Objection to Planning Application

158 Hawthorne Way, Shelley, Huddersfield, HD8 8PX

Application: Change of use of garage to treatment room for hairdressing, including installation of bi-fold doors
(Agent ref: 383-26-R1)

Council application reference: 2026/62/91926/E

Proposed Site Layout
Scale 1:250

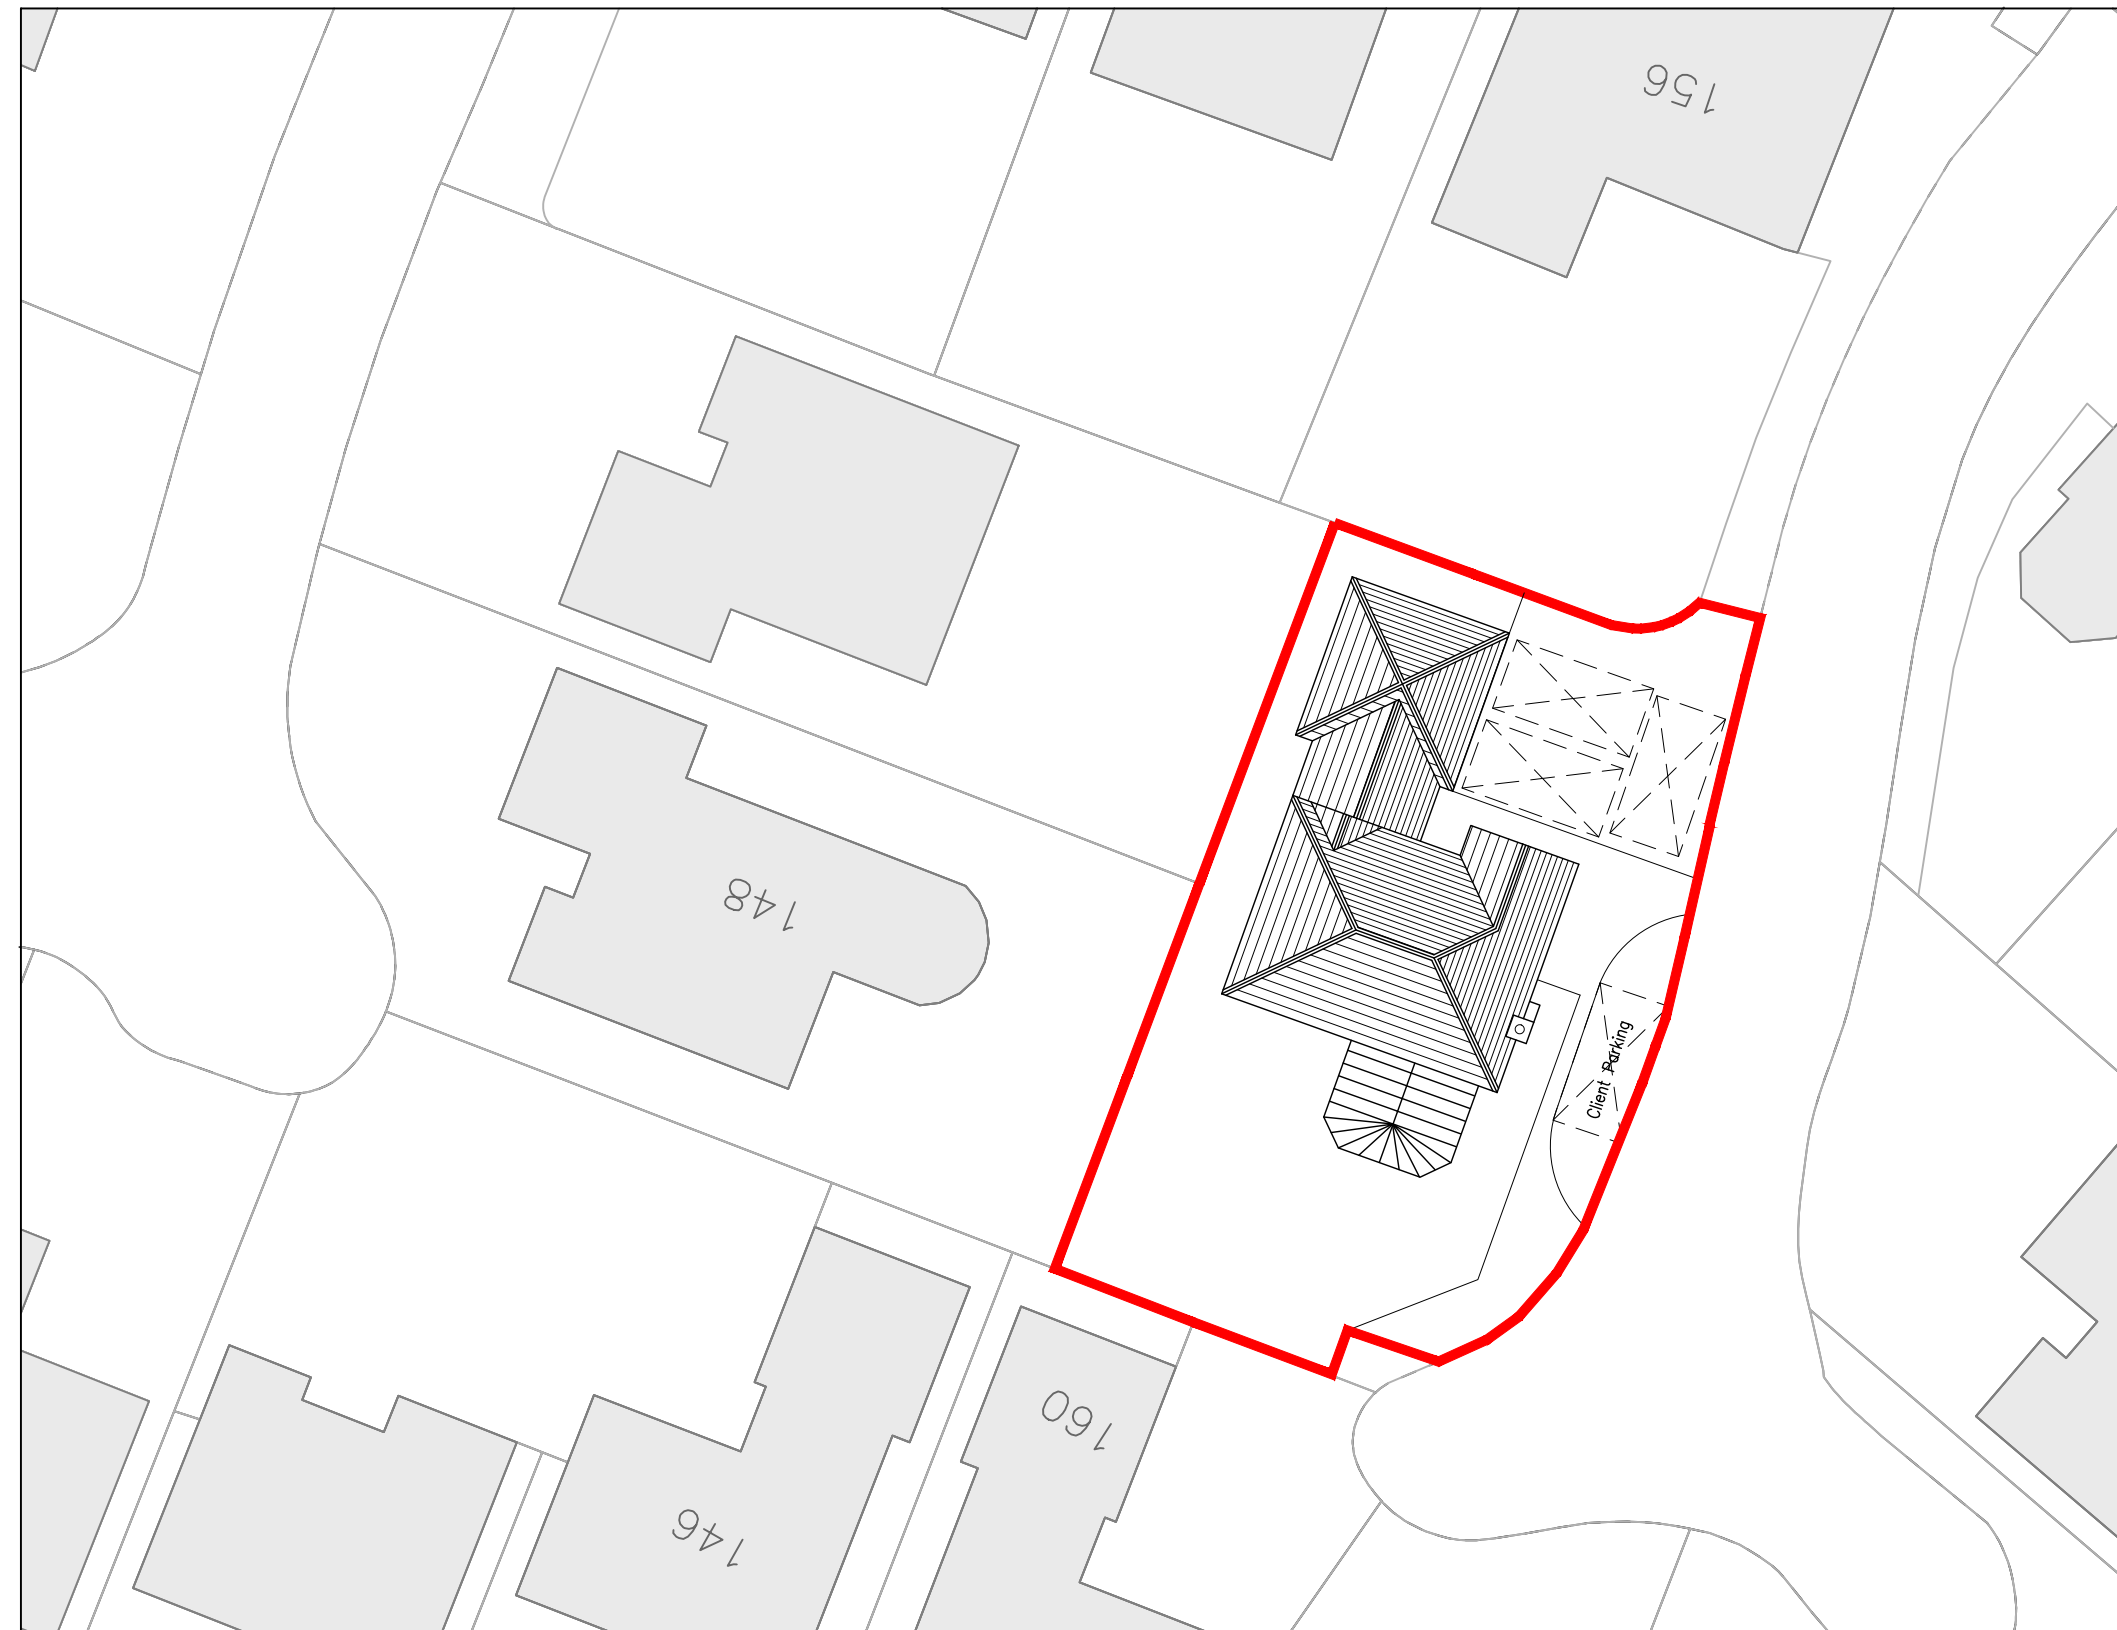
The proposed plans show three car spaces on the driveway. There is not enough space for this. Considering the room needed for opening & closing the proposed Bi-Fold doors, there will be even less space for parking on the actual driveway than there is at present should planning be granted.

The proposed plans have been drafted to include this service strip outside 158 as '158 ownership'. The driveway of 158 has already been extended into this service strip by a previous owner & the marked 2-meter strip at the end of the driveway removed after being resurfaced. More recently, it was extended again into more of the service strip, I believe without planning or proper drainage.

The proposed plans seem to include an area depicted above, that does not belong to 158.

The applicant's below submitted plan has been altered to include the service strip and parking bay 'as theirs' when it's clear the 'thick' boundary line is to the property fence (in yellow), which then continues down the same trajectory to the wall of 156 below... I dispute this service strip now belongs to 158.
